**RE: SUBMISSION TO SSD-82899468 FOR RESIDENTIAL FLAT BUILDING WITH INFILL AFFORDABLE HOUSING**

I refer to the State Significant Development Application SSD-82899468 for the purpose of a Concept Development Application (**Development**) seeking concept approval for the demolition of existing buildings and associated structures, tree removal and site clearing and construction of a multi-storey residential flat building with in-fill affordable housing above basement car parking and associated landscaping at No. 1-5 Nelson Road, Lindfield (**Site**).

01. PROPOSED CONCEPT MASTERPLAN

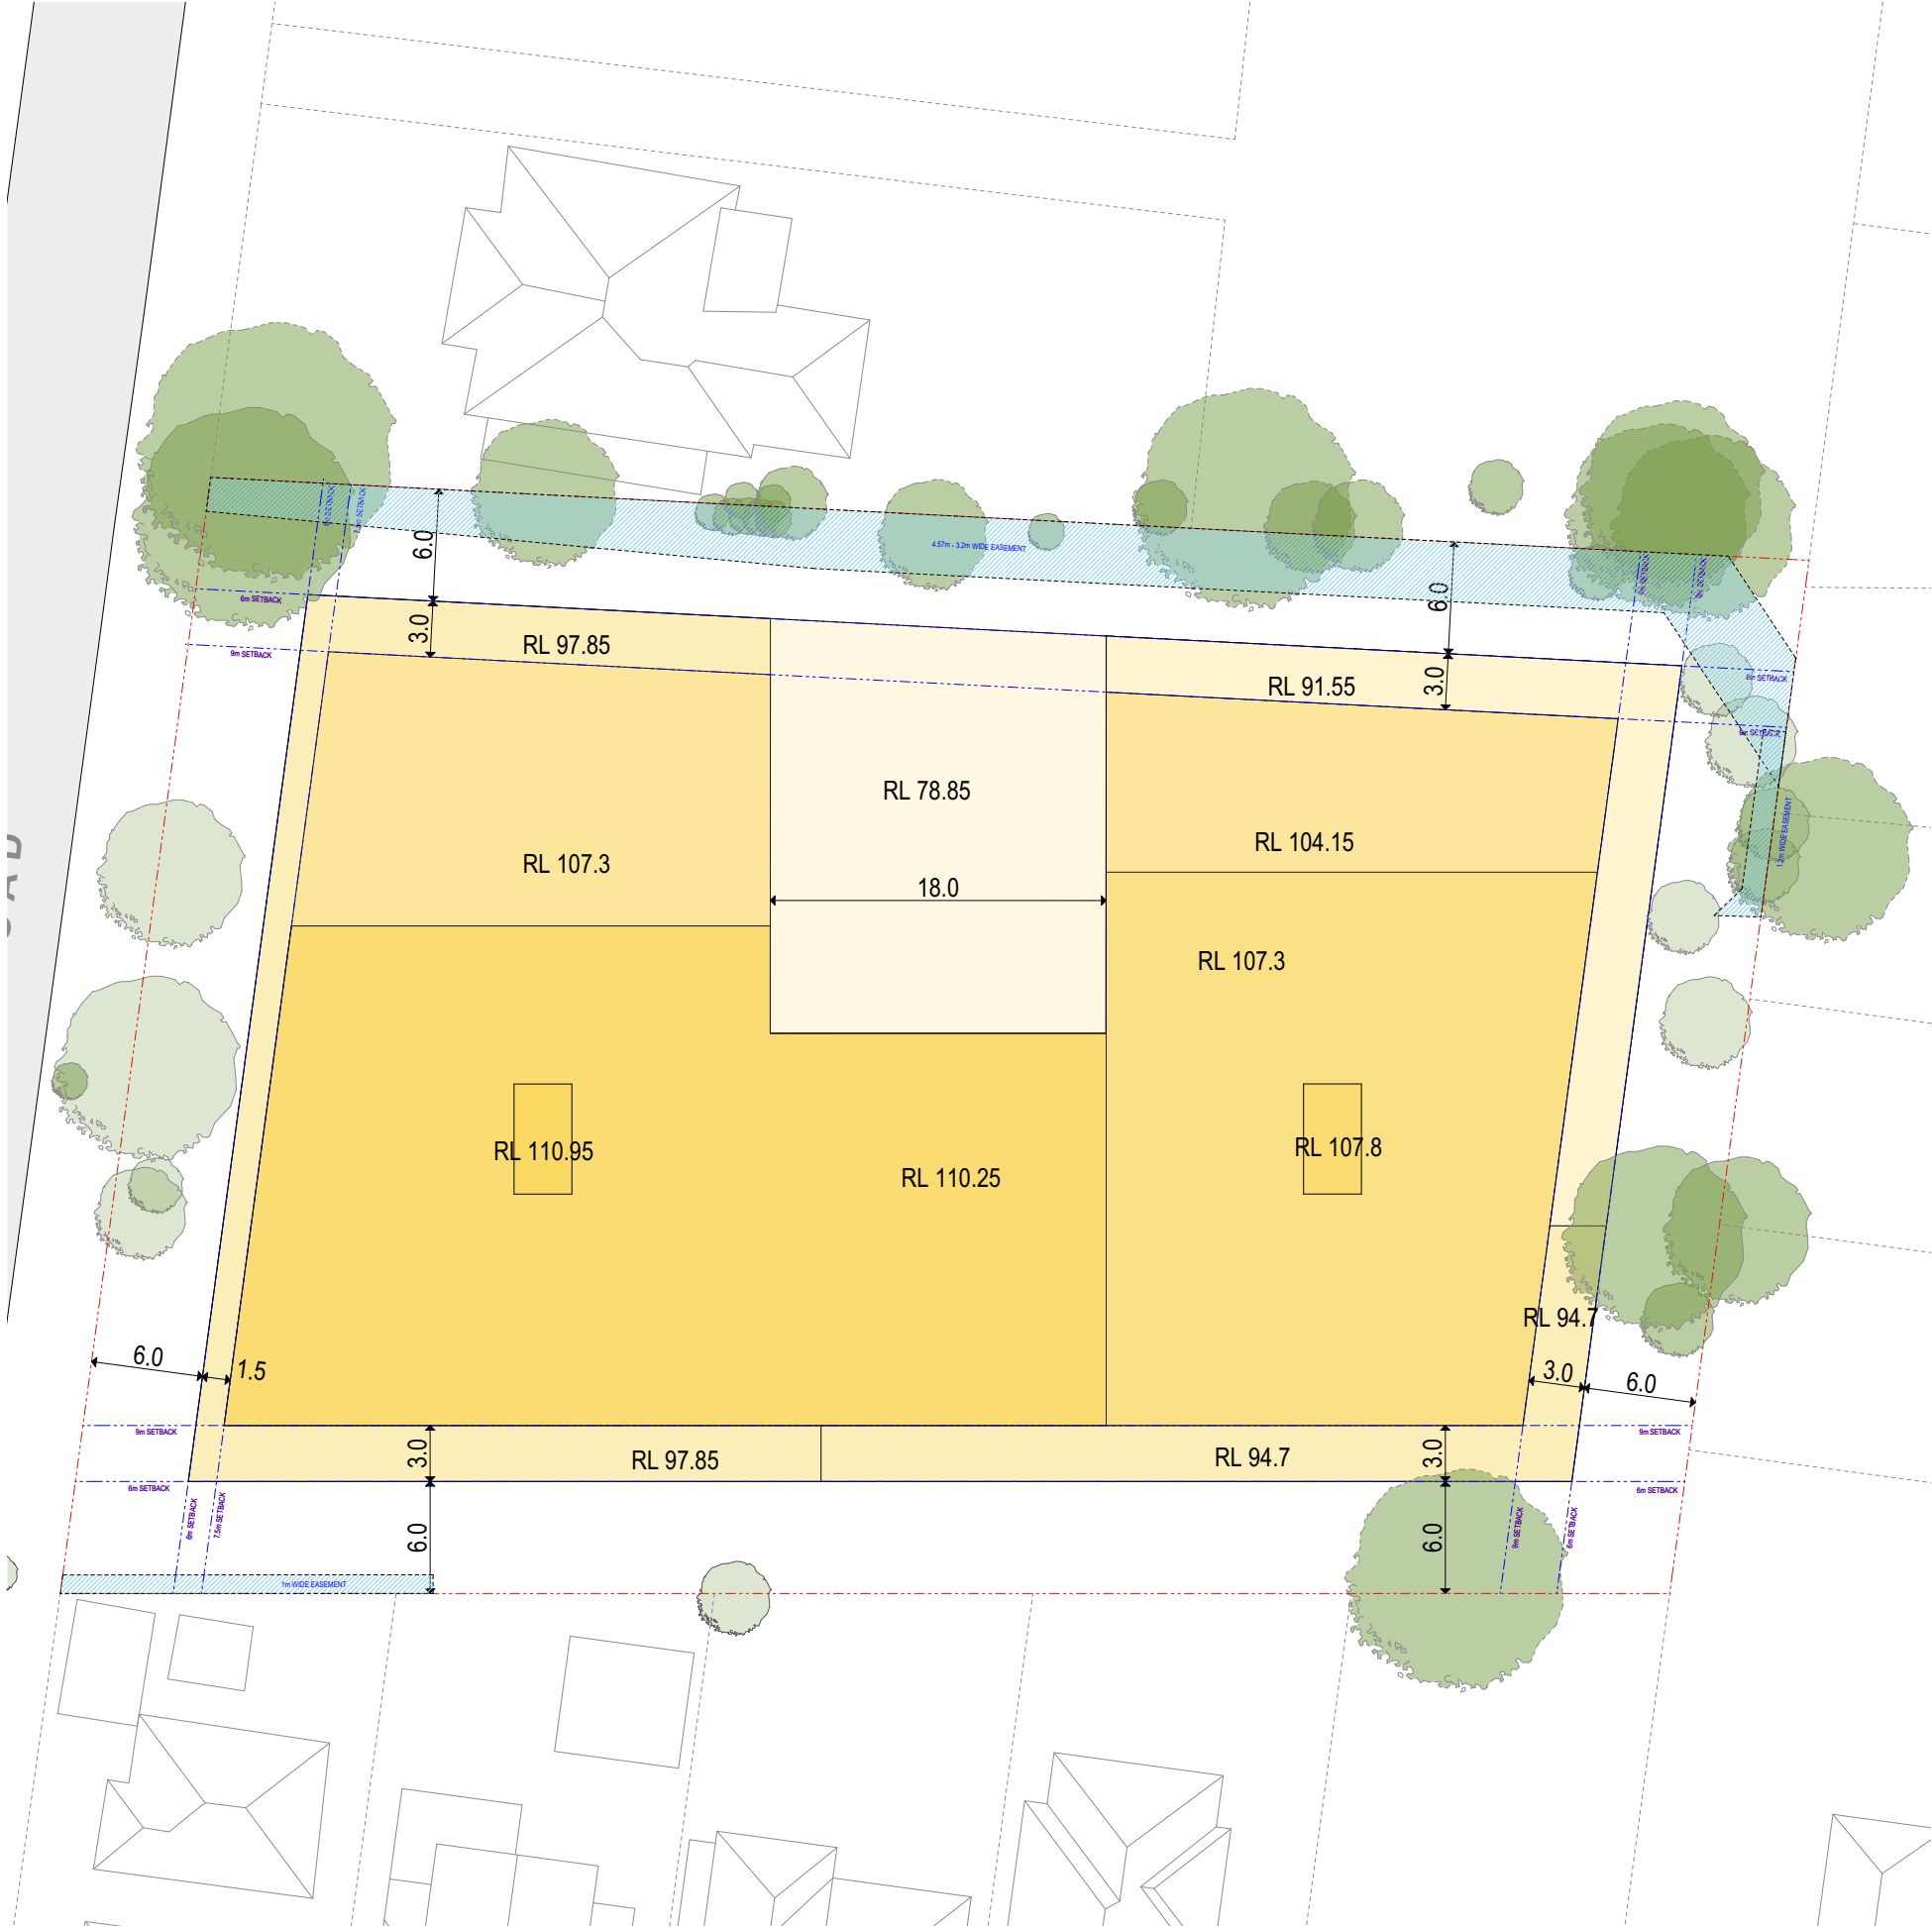
Category 3 Riparian Land requires a protected zone of 10m from the banks of the waterway, so 10m from the banks of the creek in this case would require a much wider setback from the northern and eastern boundaries than the proposed 6m setback on the current concept plan.

Category 3a Riparian Land requires a protected zone of 10m from the centre of the waterway, which would require a much greater setback from the northern boundary, not 6m as is currently being proposed.

Indeed, given the existence of the creek, I cannot understand how the concept plan can proceed as represented in the EIS since part of the building at the northeast corner will be built directly over the top of the creek.

NORTH ELEVATION

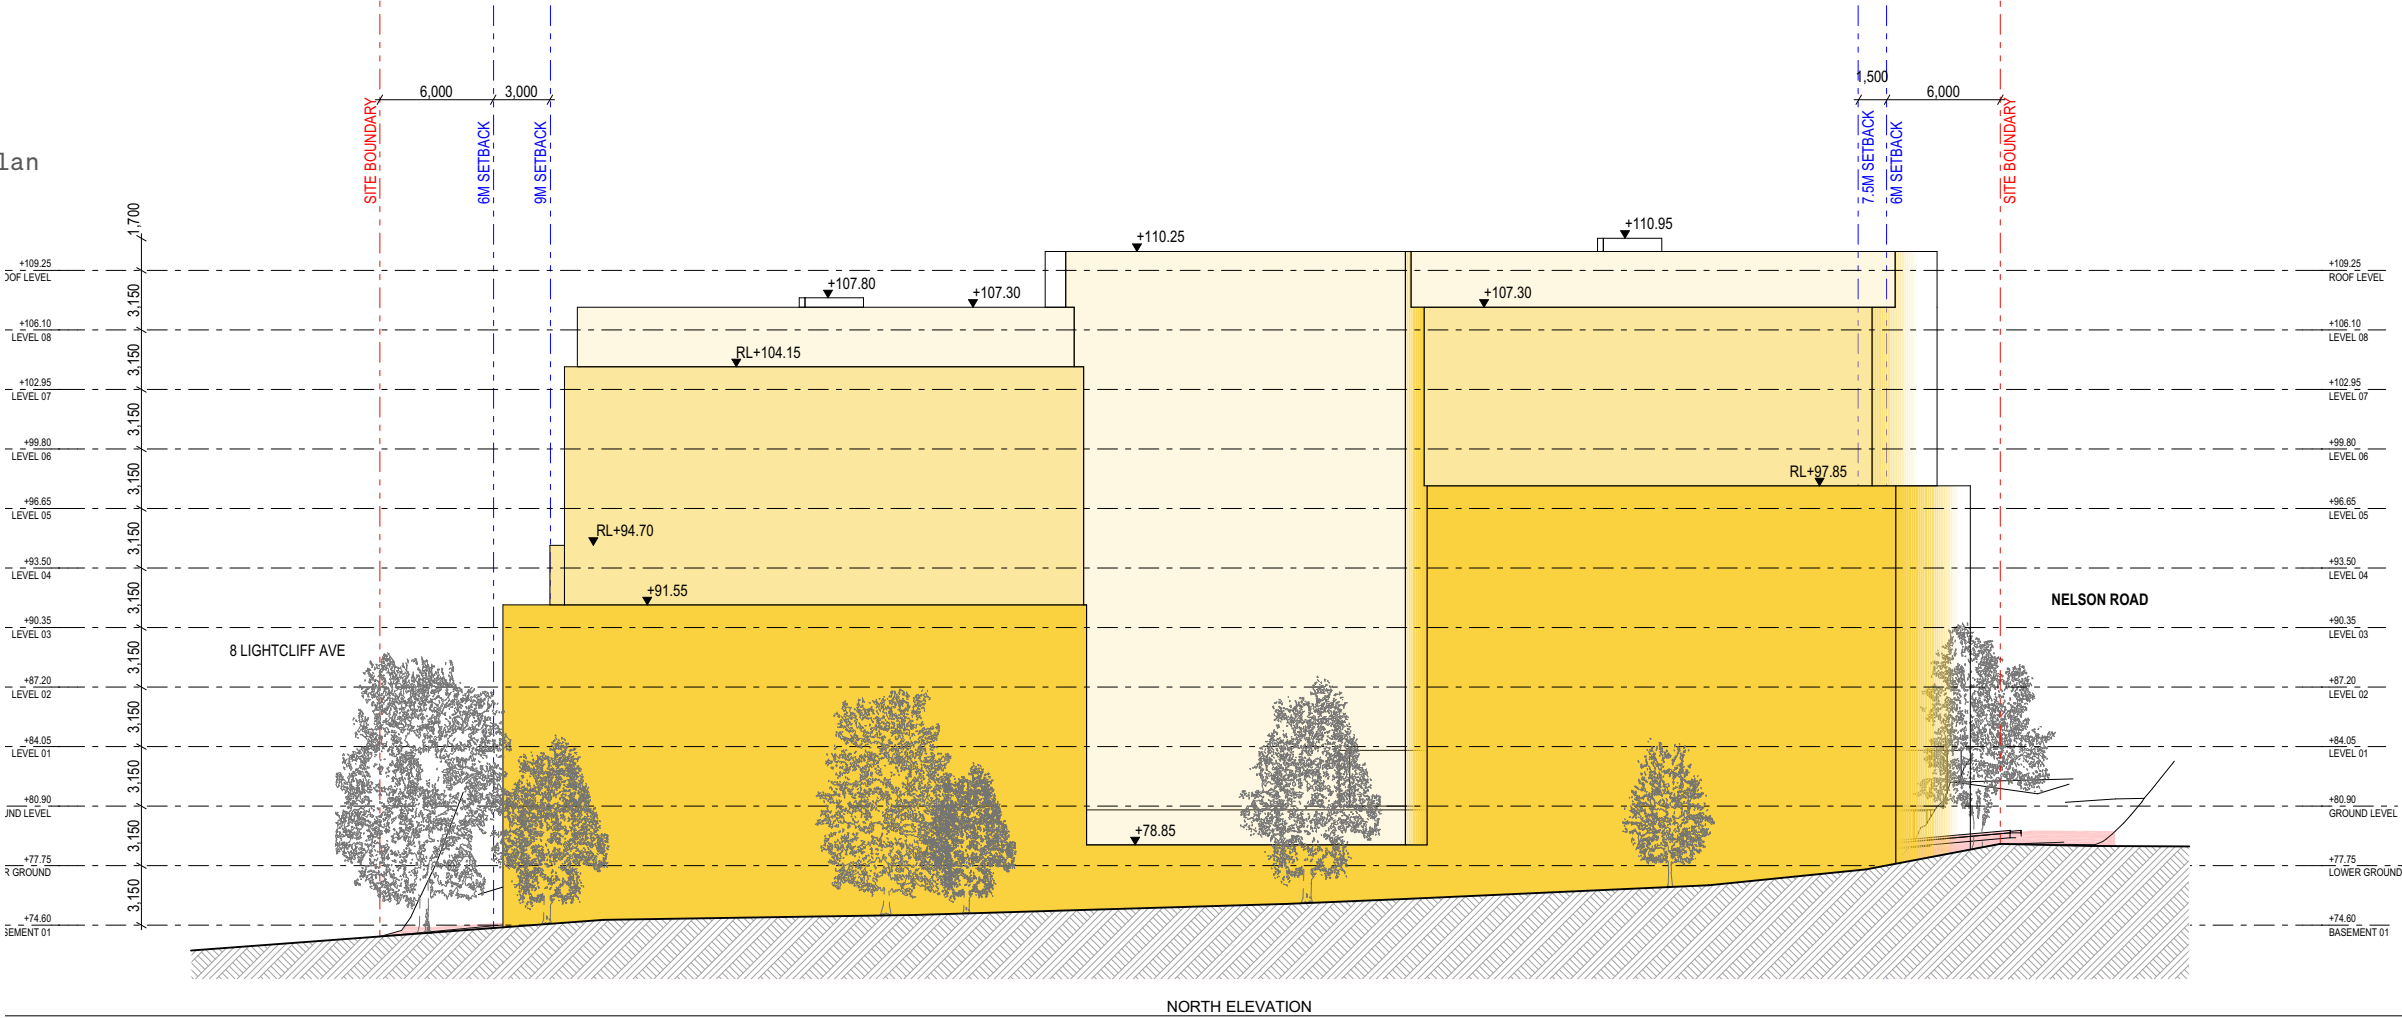
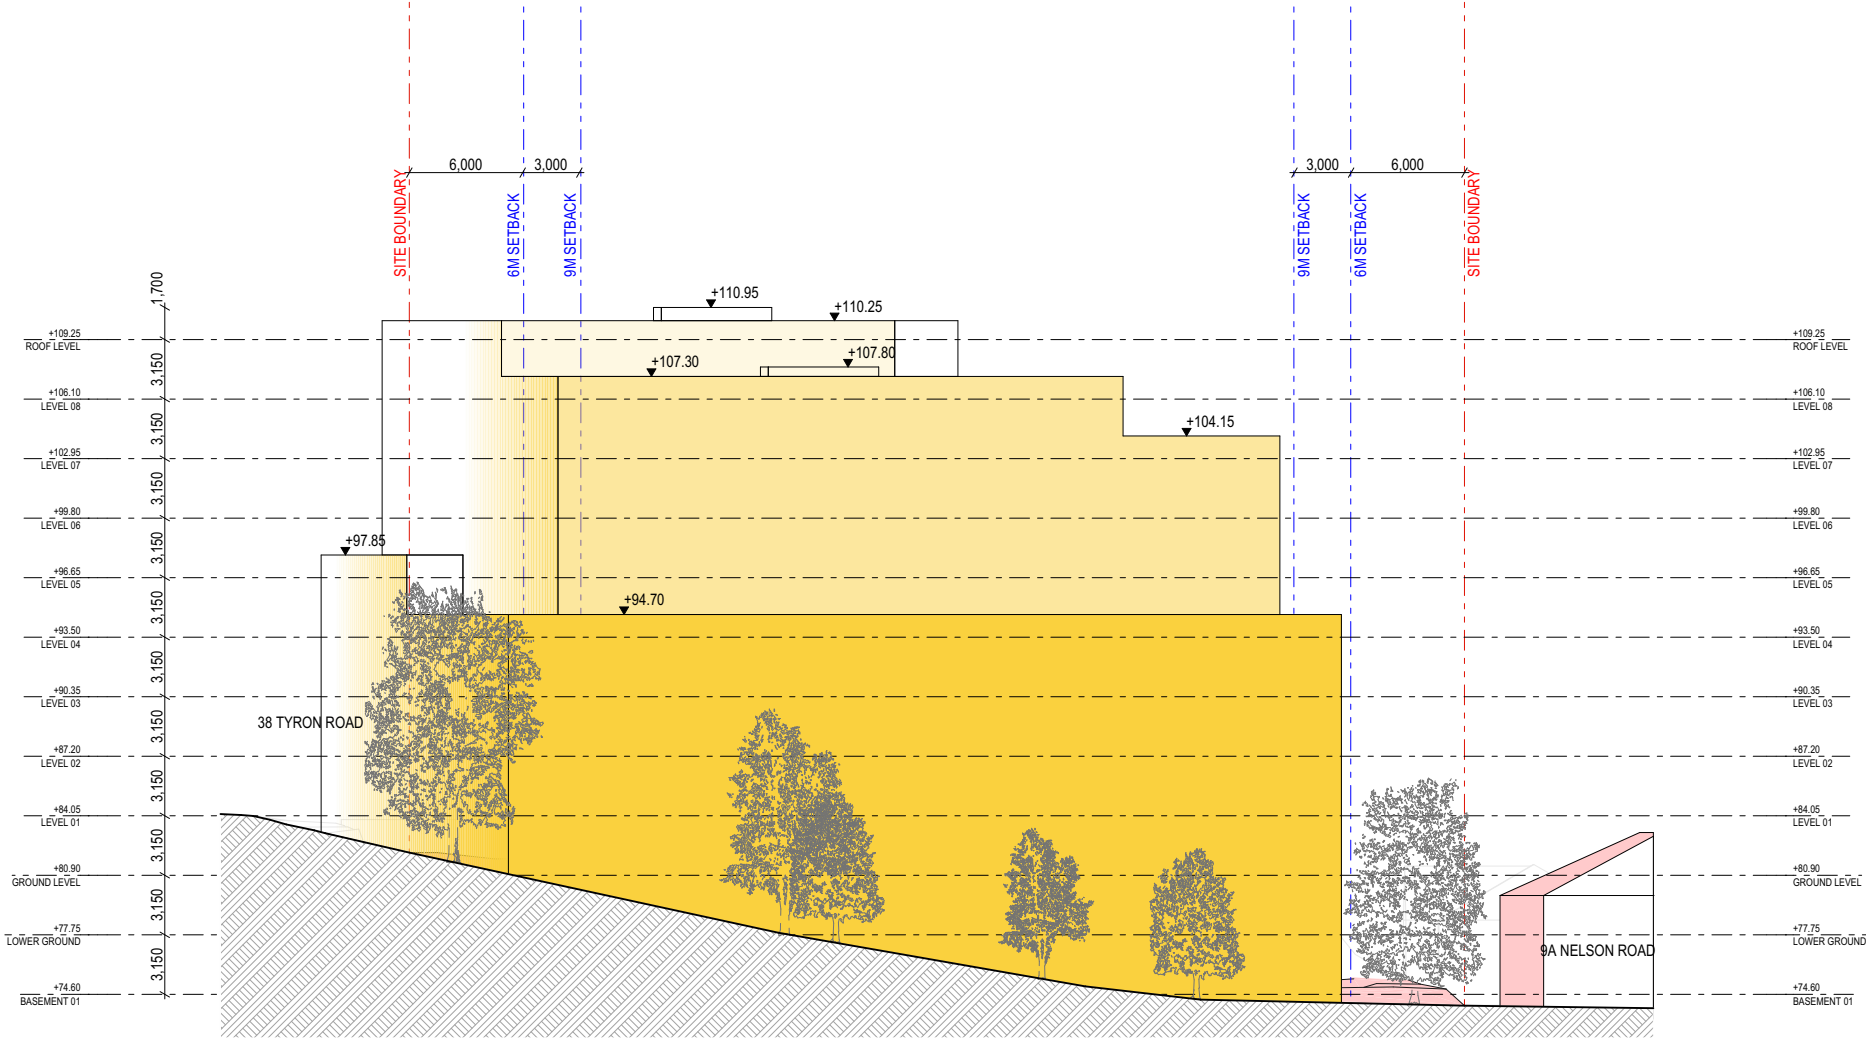
Given the sloping nature of the land, what is 9-storeys when viewed from Nelson Road is in fact 11-storeys when viewed from the north and east. I refer you to the Elevations in the Proposed Concept Masterplan (Appendix 9) showing my house (a two-storey residential dwelling) being towered over by an 11-storey building located on the other side of our shared boundary:

Whatever the Applicant and its paid consultant's might say to the contrary, there is simply no way that this can be assessed as being an appropriate interface with adjoining low density zoned properties, such as my own.
